**Re: Objection to MP08\_0244 MOD 1 Modification Request for Mixed Used Development at 23-37 Lindfield Avenue and 11 Havilah Lane, Lindfield**

As a resident of Lindfield, I/we wish to lodge an objection against the proposed Modification of the subject development based on the following grounds:

3 SHADOW DIAGRAM - 21stDEC_3PM
5003 SCALE1 : 650

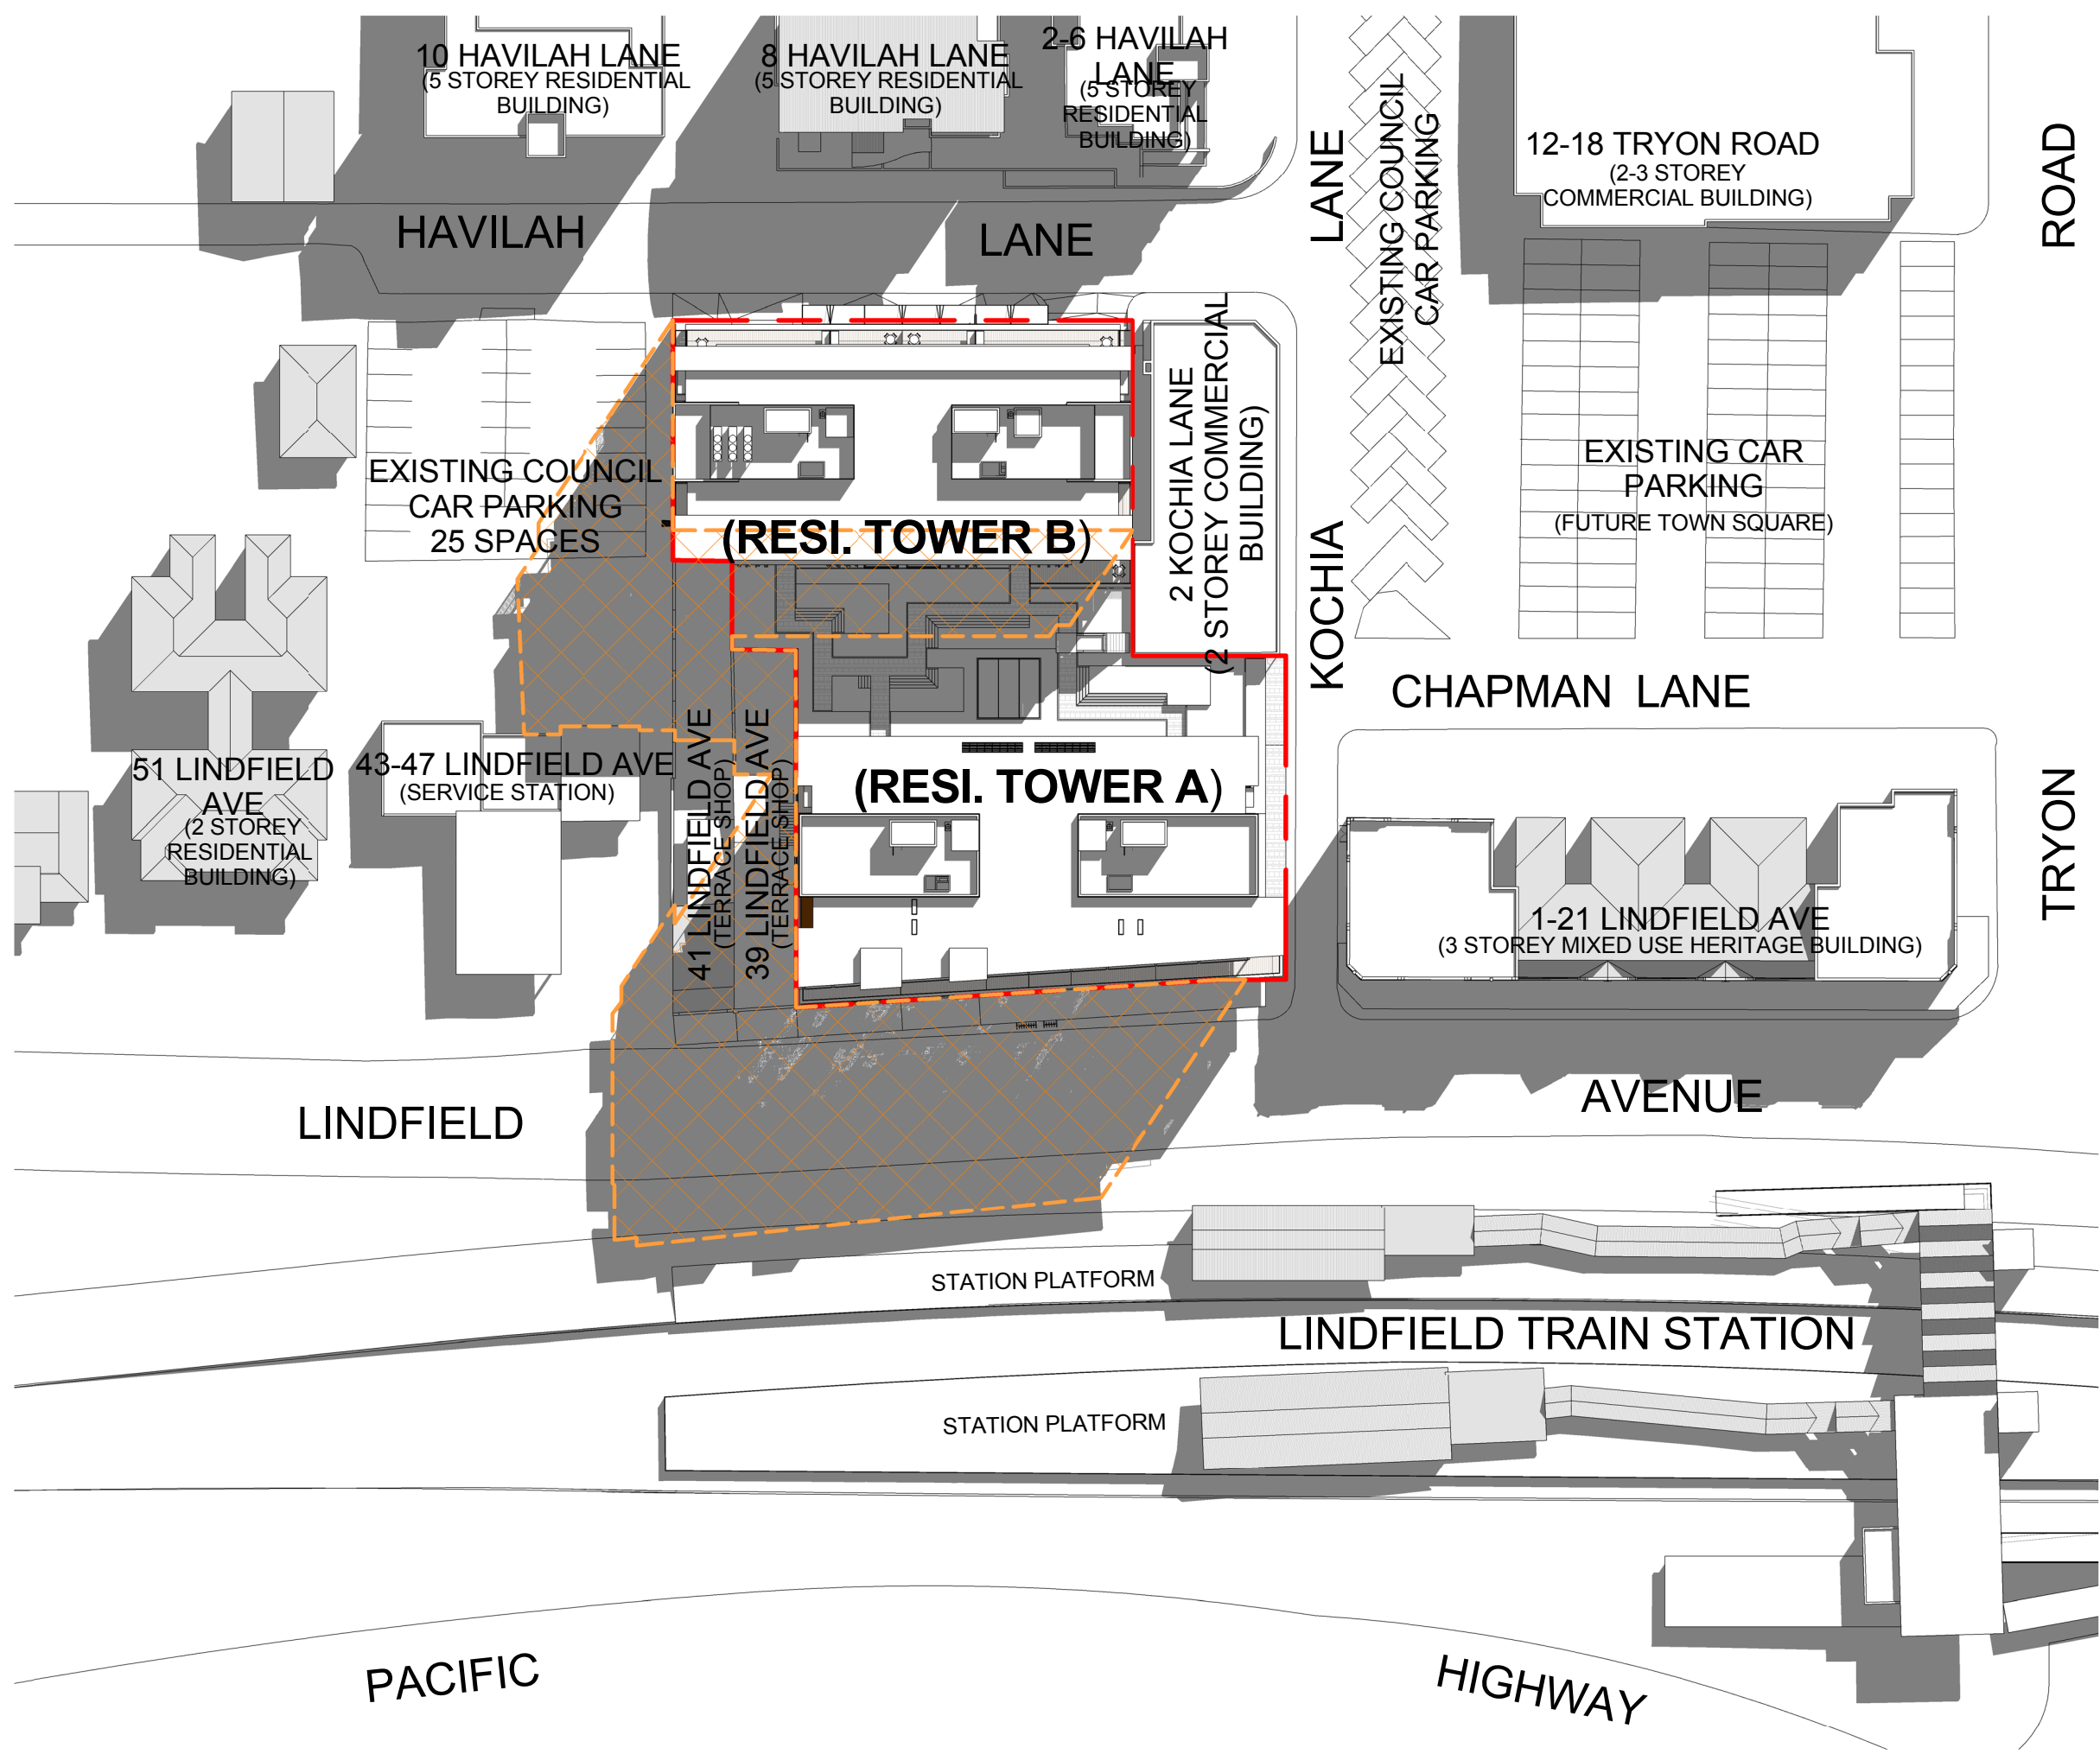
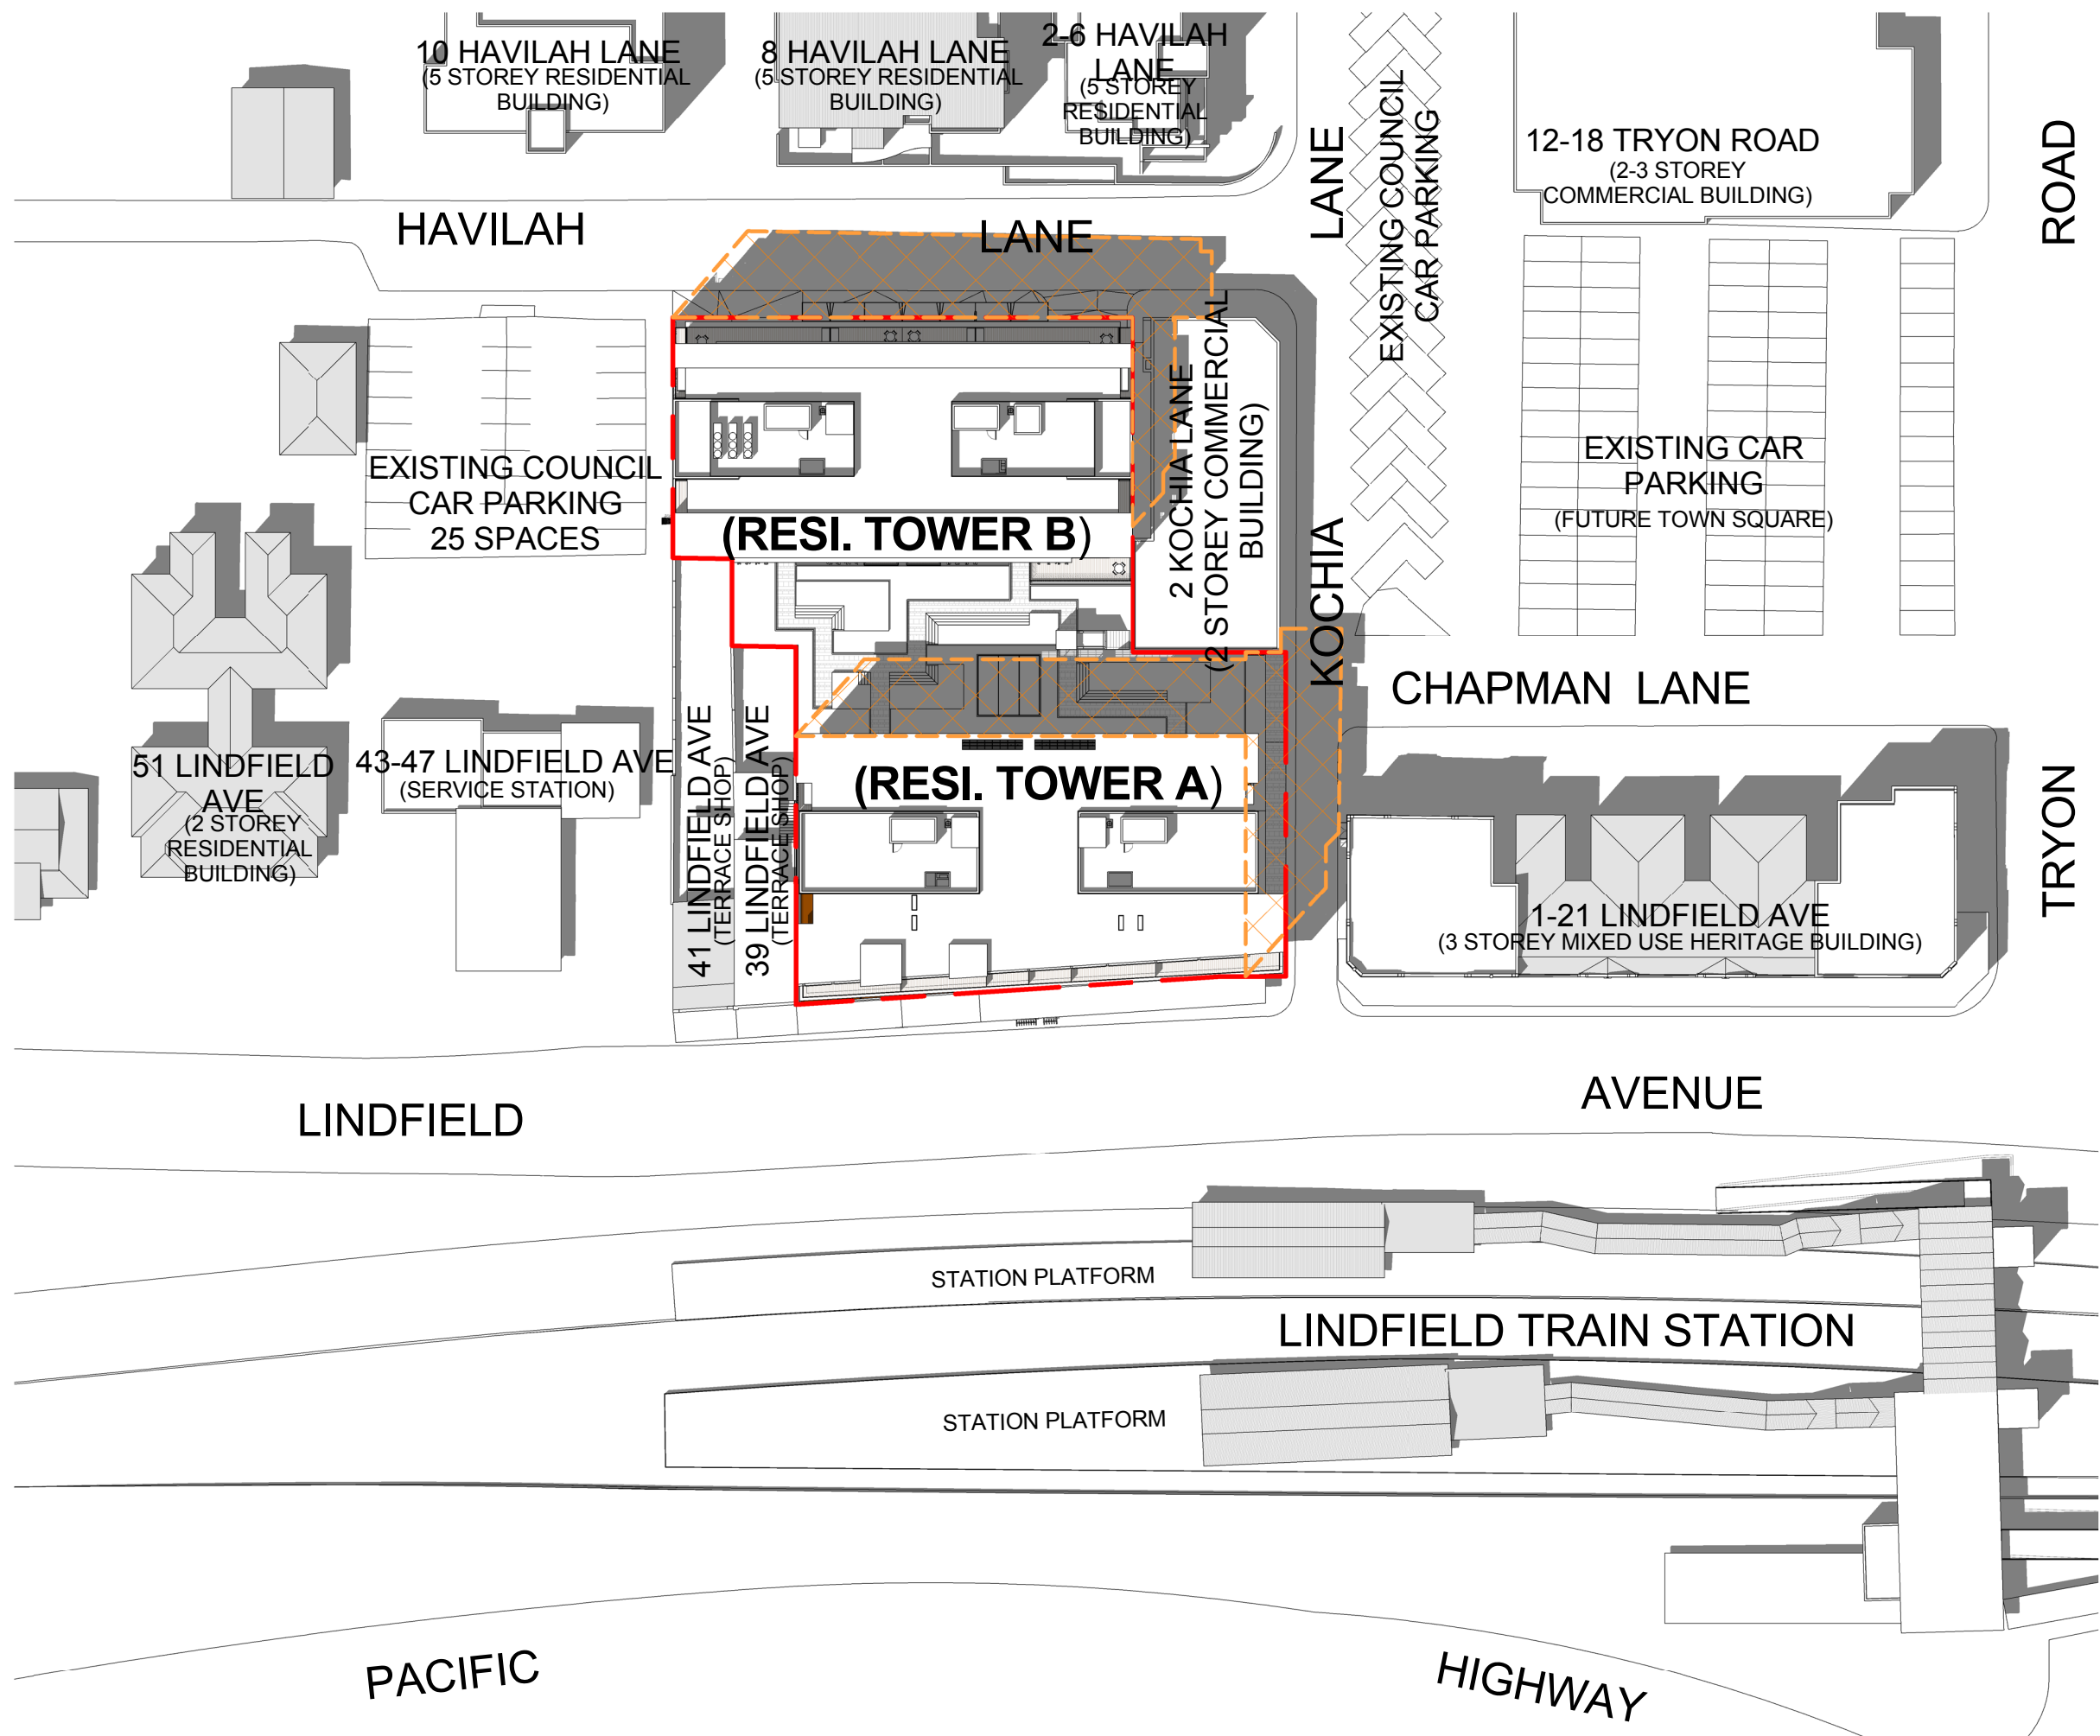
- The additional storeys create additional shadowing: particularly after 3pm for residents in the Havilah Lane apartments, and for all commuters on the city bound Lindfield rail platform, instead of 50% of the year, it will now be 75% of the year in the mornings.
